**Application by Aquind Limited for a Development Consent Order
for the 'Aquind Interconnector' electricity line between Great Britain
and France (PINS reference: EN020022)**

**Comments on the ExA's further written questions (ExQ2) [PD-031]
(question references LV2.9.1 and LV2.9.2) and related appendices**

On behalf of

Plate 3.4 - Proposed Eastern and Western connection bays at Lovedeane Substation.

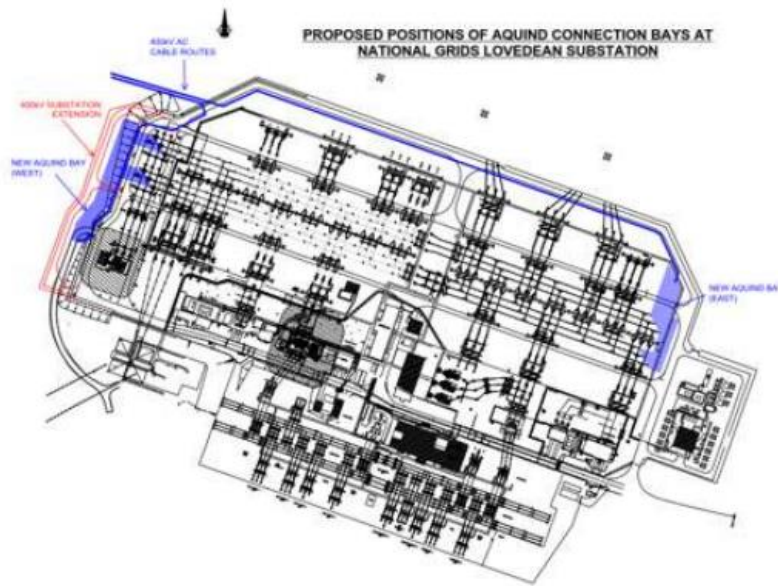
9. Firstly, assuming that the permission for that sub-station extension may not have lapsed in September 2016 because, despite its age there is evidence of discharge of conditions including pre-commencement conditions, and because the Applicant's [APP-118], 6.1.3 Environmental Statement - Volume 1 - Chapter 3 Description of the Proposed Development, includes at Plate 3.4 Proposed Eastern and Western connection bays which shows the constructed bays:

10. Plate 3.4 of the Environmental Statement [APP-118] includes in red a notation describing the "substation extension".
11. If the permission has been saved by the undertaking of some material works by National Grid constituting lawful implementation then it is notable that the permission has not been identified to date in documents such as the Onshore Short List of Developments [APP-347, Sheet 1, and APP-347(a), Sheet 1] *against which* environmental effects are assessed [APP-144]. But, [APP-110], 5.4.2 Planning Statement - Appendix 2 Planning History, Table 1, Planning History, contends that Planning Permission reference 13/01025/F for the:

12. If implemented, there seems no actual need to include it as "authorised development".
13. If secondly, alternatively that planning permission has lapsed and is envisaged to be delivered as a new element part of the Application then it appears to constitute a change and ought to have been included from the start and not sought to be shoehorned in at this late stage and
